Your Ref: OWPC18940
Our Ref: P/49/18/HH 30-04-2018
Please ask for:
Mr S Davis

2 storey infill extension to front elevation & 1st
floor infill extension to rear elevation.

39 Conway Drive Pagham

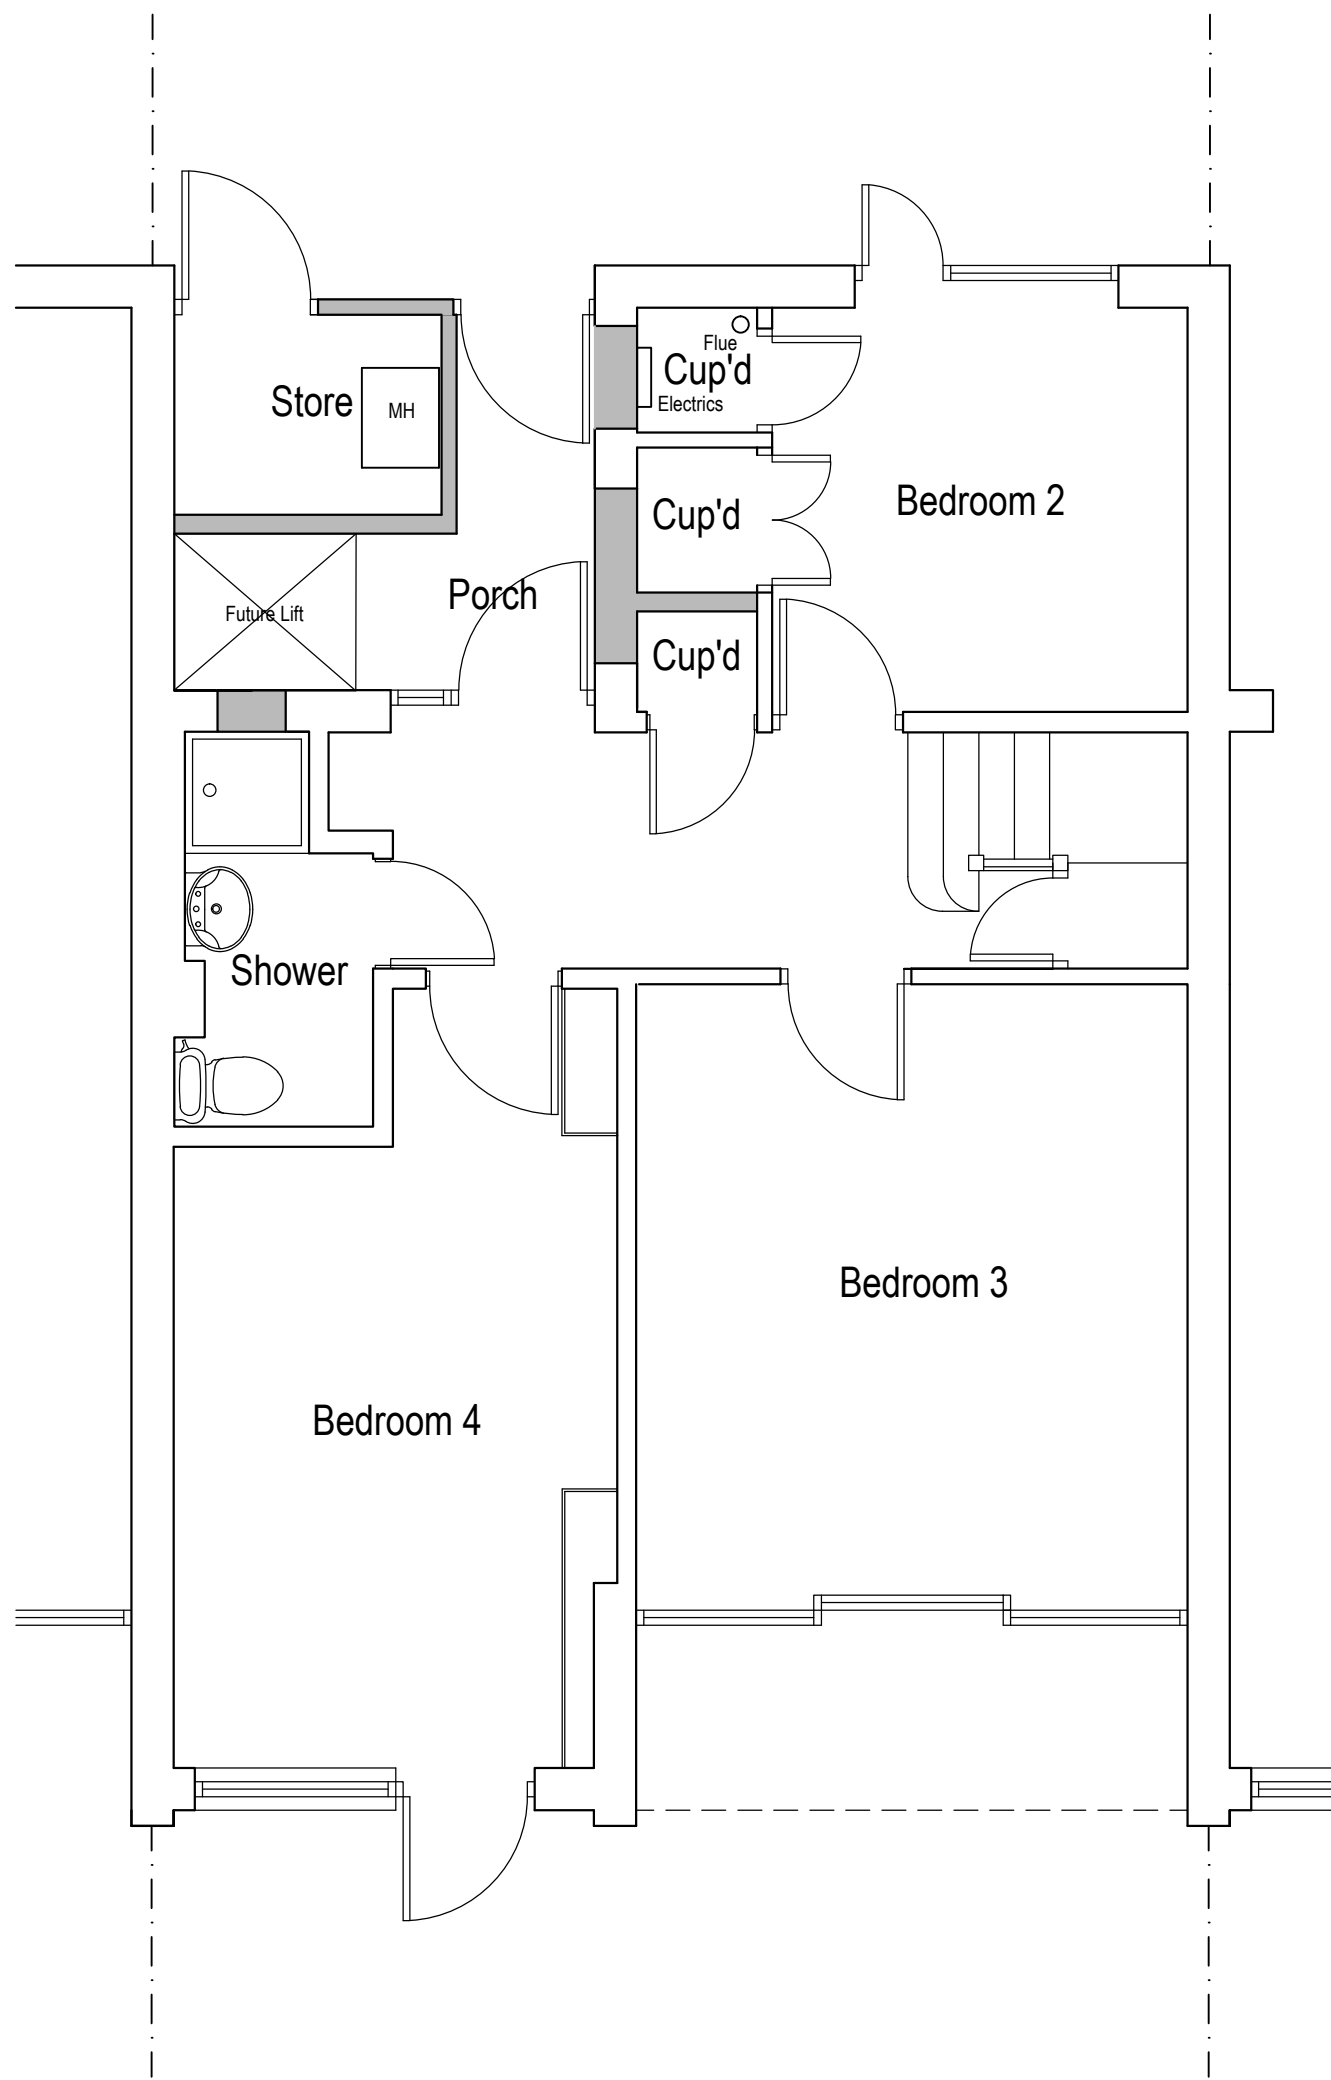
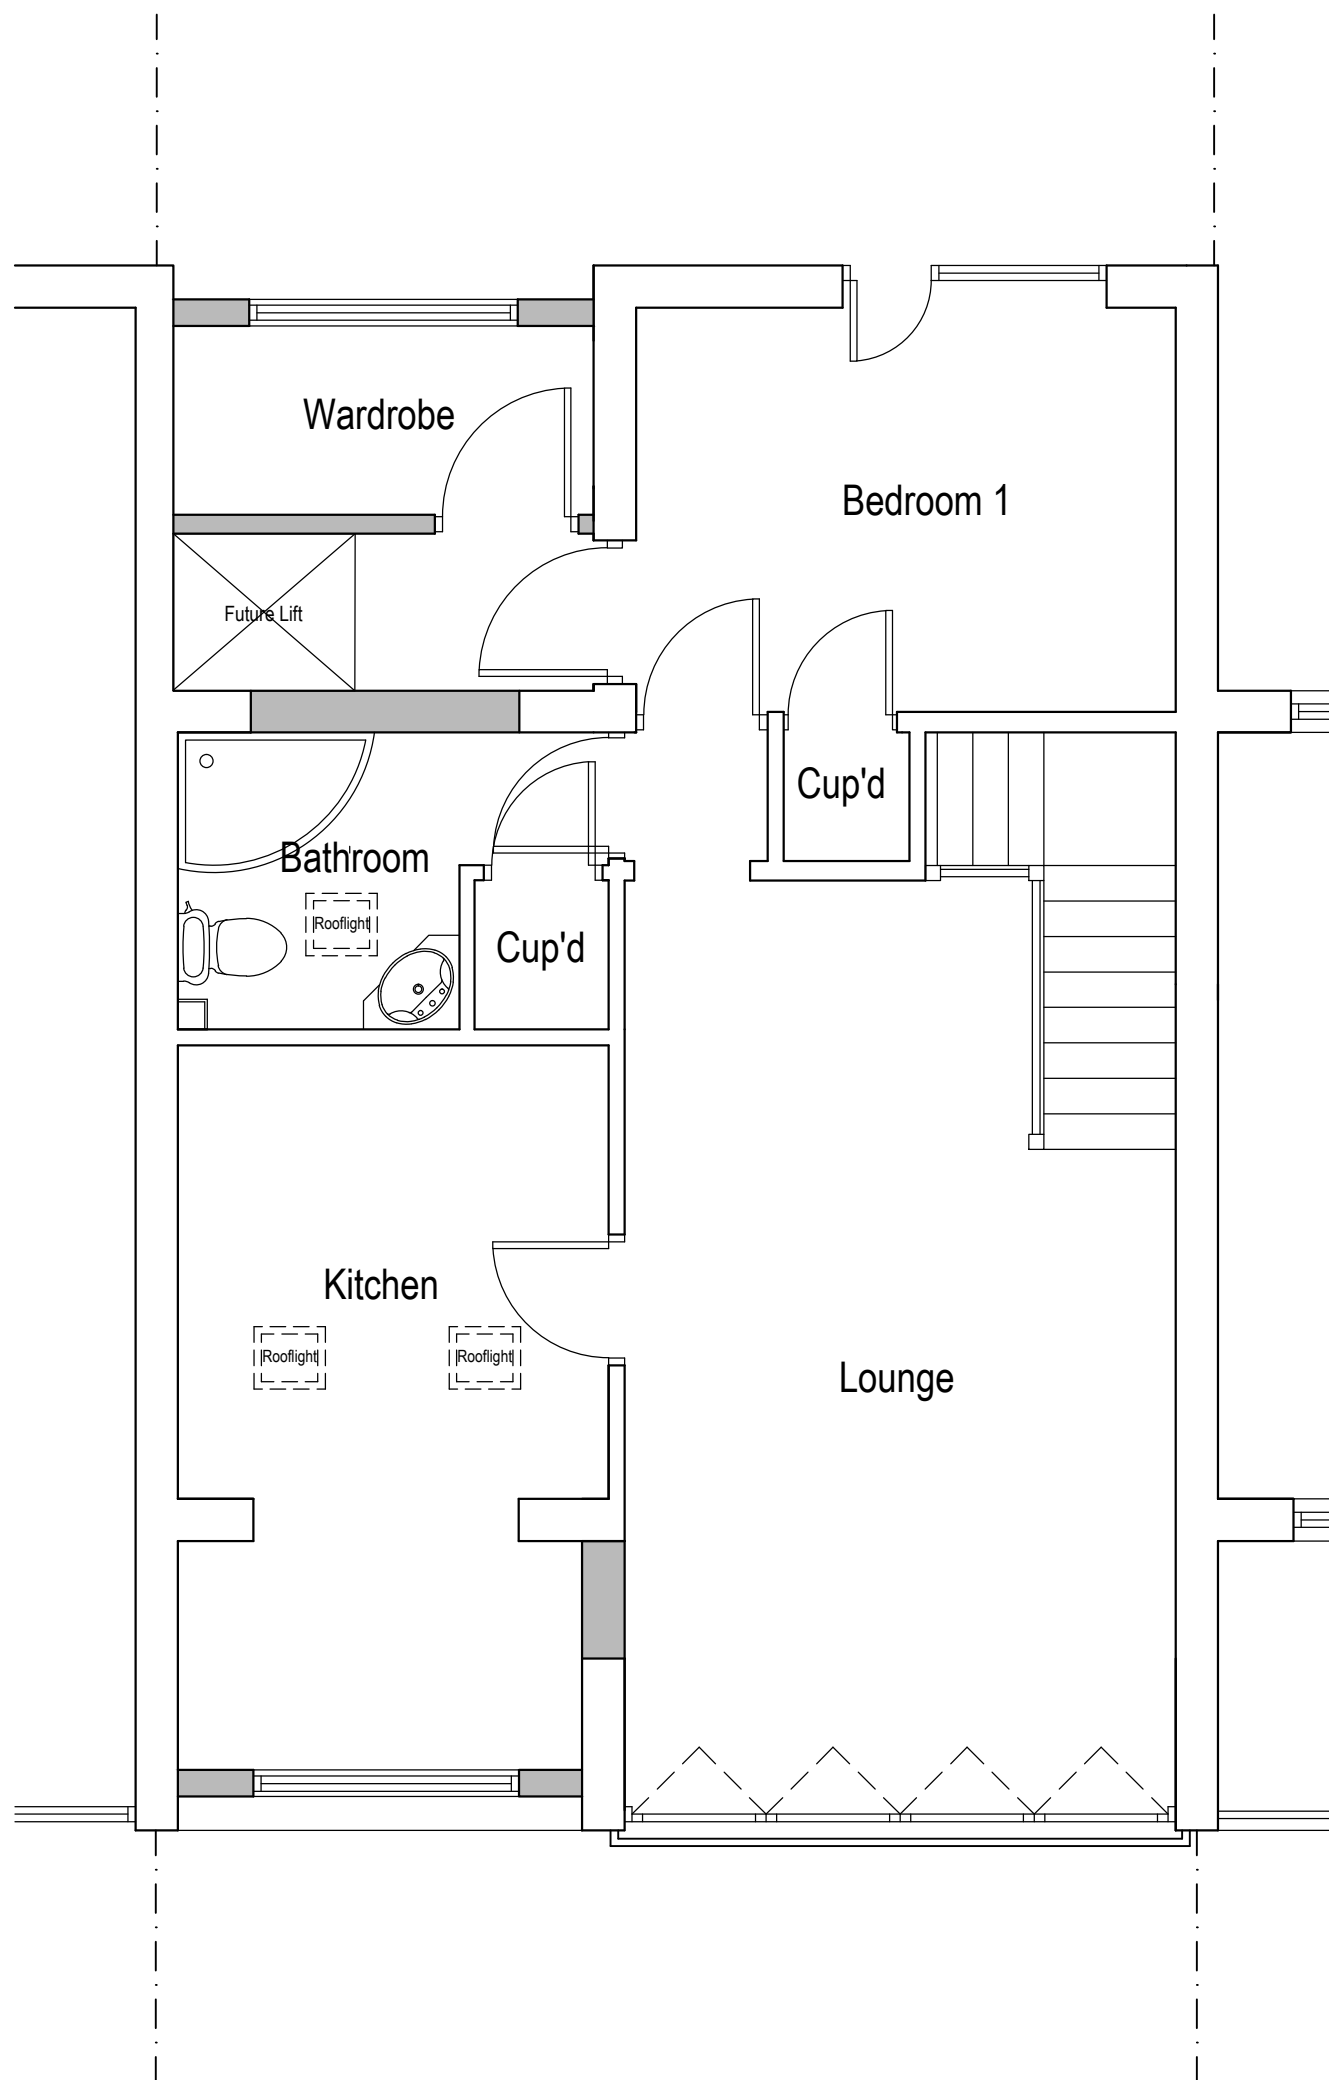
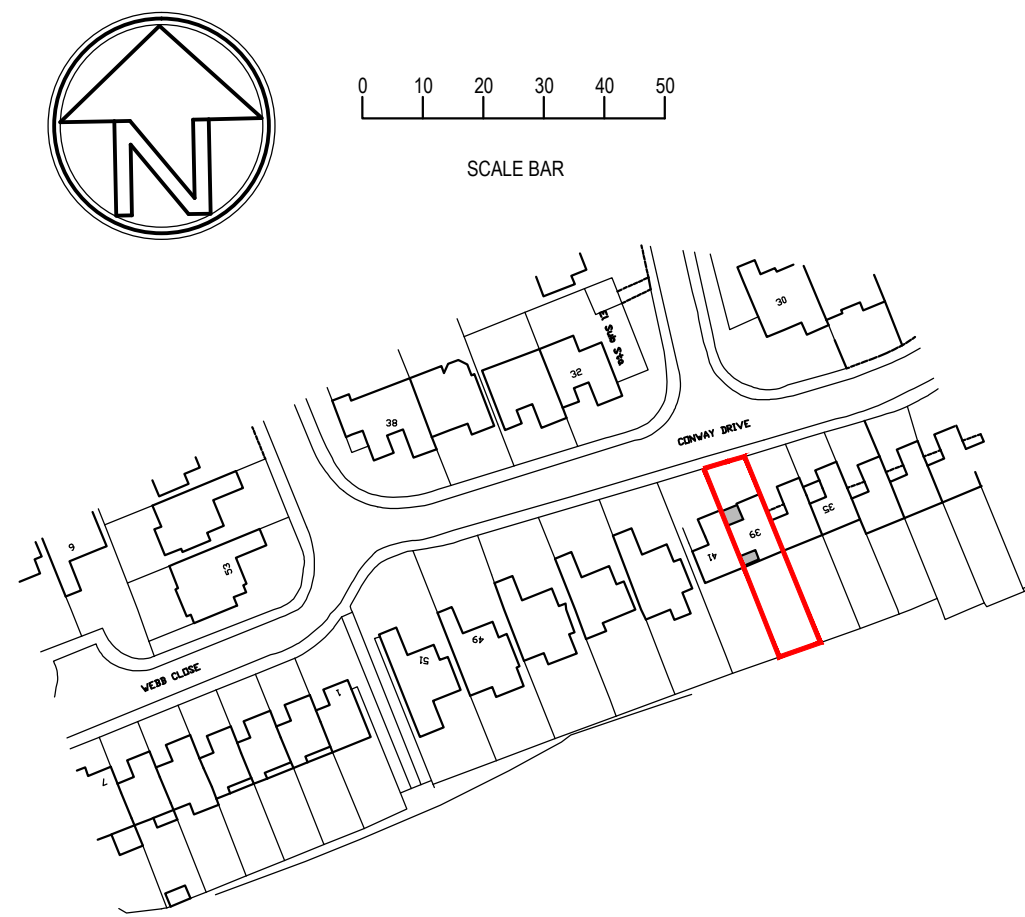
As a new resident to Conway Drive I am supportive of all efforts to improve local properties, so long as any improvements are appropriate and sensitive to the preservation of the visual character of the neighbourhood. I feel that the terraced house appearance indicted by this proposal would have an adverse effect on the unique link detached style of the properties in Conway Drive.

These houses have very poor sound insulation; this would be exacerbated by noise transmission through increased party wall dimensions.

The proposal could be amended, without changing the current, overall footprint, to take the above issues into consideration yet still afford occupants increased living space, improved convenience and greater flexibility.
